Development Management
Lincolnshire County Council
County Offices
Newland
Lincoln LN1 1YL
Tel: 01522 782070
developmentmanagement@lincolnshire.gov.uk

Application Ref: H16-0584-25

Proposal: **Hybrid application: Full planning application for the erection of 160 dwellings and associated infrastructure, demolition of existing buildings and outline planning application for the erection of up to 274 dwellings**

Location: **Land off Monks House Lane, Spalding, PE11 3LH**

DRAINAGE STRATEGY
GENERAL ARRANGEMENT
SHEET 2 OF 2

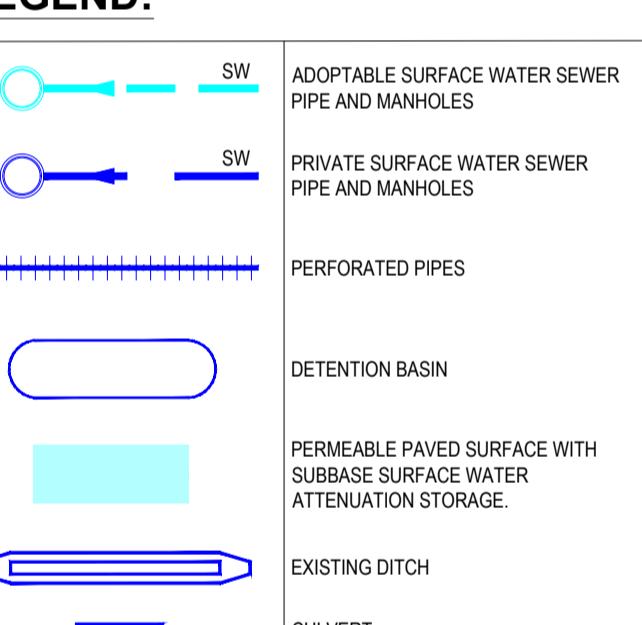
Drainage needs to be detailed for the whole site – full and outline.

The existing watercourse that runs through the site and is proposed for discharge – is this Riparian or IDB maintained?

Private water should not drain into the sws.

Urban creep 10% needs to be added to the calculations.

This is not a SuDs design and will not be accepted. There needs to be more above ground attenuation. Gravity swales could be incorporated instead of filter strips. We would not accept such large pipes that are detailed and we would never adopt them (1200mm/1500mm are unacceptable). They would definitely require a commuted sum.

Unsightly headwalls with railings are not something we would accept.
